From: Ian Gledhill [REDACTED]
Sent: 03 November 2020 16:07
To: Michael Eastham <Michael.Eastham@arun.gov.uk>
Cc: Planning.Responses <Planning.Responses@arun.gov.uk>
Subject: WSCC Highway Comments - BE/121/2- - Revised Construction Management Plan for Saltbox

Hello Michael, with respects to the substitute Construction Management Plan, I've no particular concerns.

Logistics and Traffic Management Plans

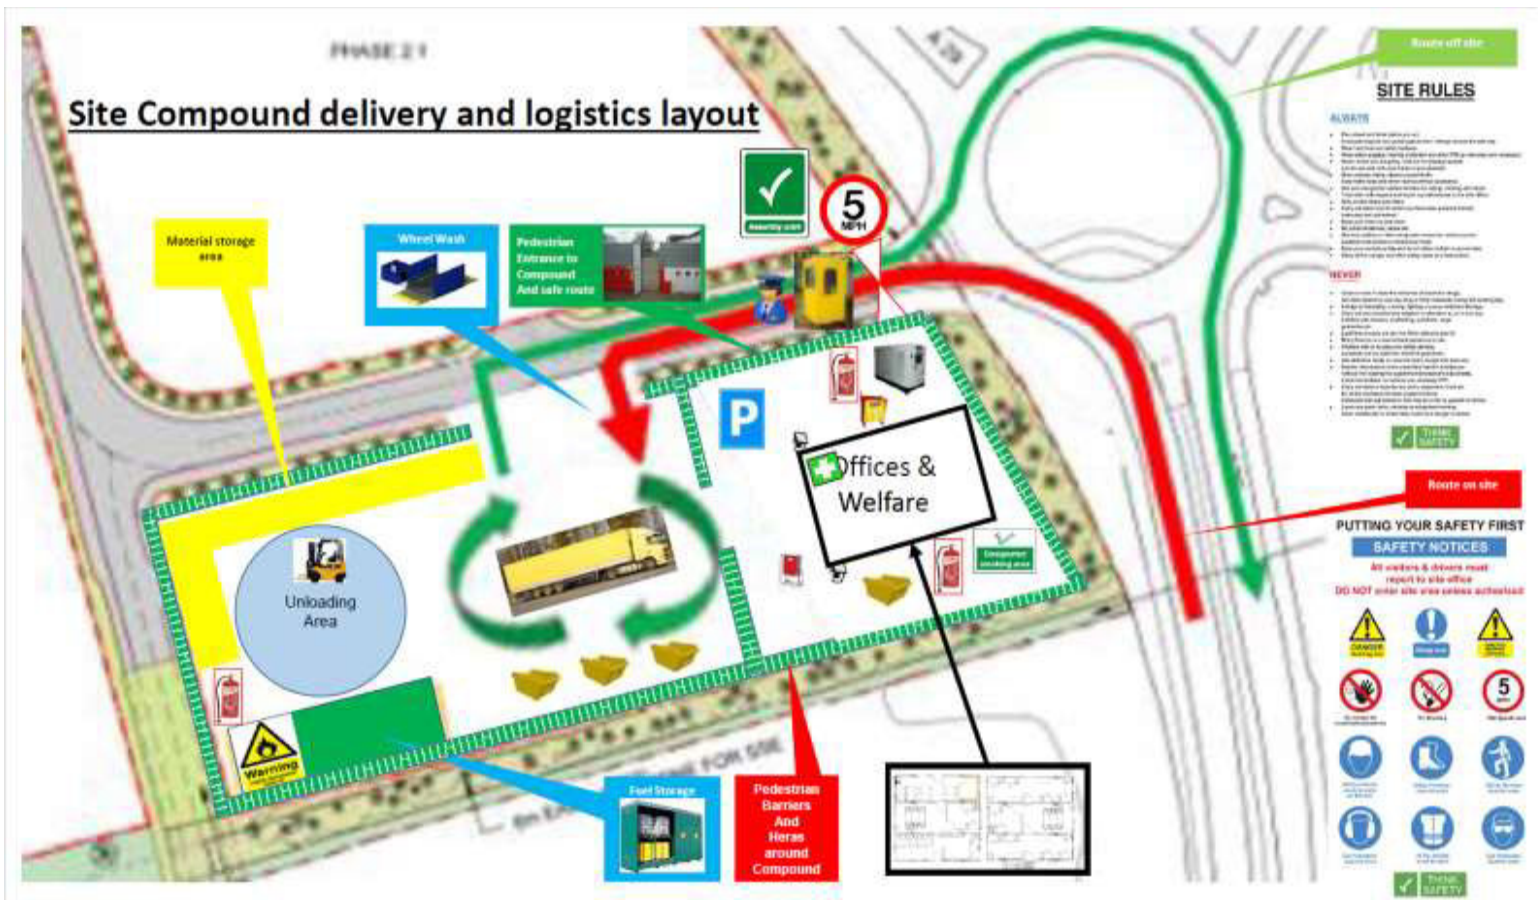
Access is now available from the additional arm off the Felpham Relief Road Roundabout rather than the existing field access to the north, so this has simplified highway matters. The only comment I'd have is in respects of the routing as shown on the Logistics and Traffic Management Plan in appendix 3. This plan shows all deliveries arriving and departing to the south. This isn't an issue in itself, but it is prescribing unnecessarily that all deliveries are required to arrive and depart to the south. There's no reason why traffic couldn't use the A29 to the north or the A259 to the east. I'd have no issue with this plan being amended so as to allow deliveries to arrive via any of the A roads in the vicinity of the site.
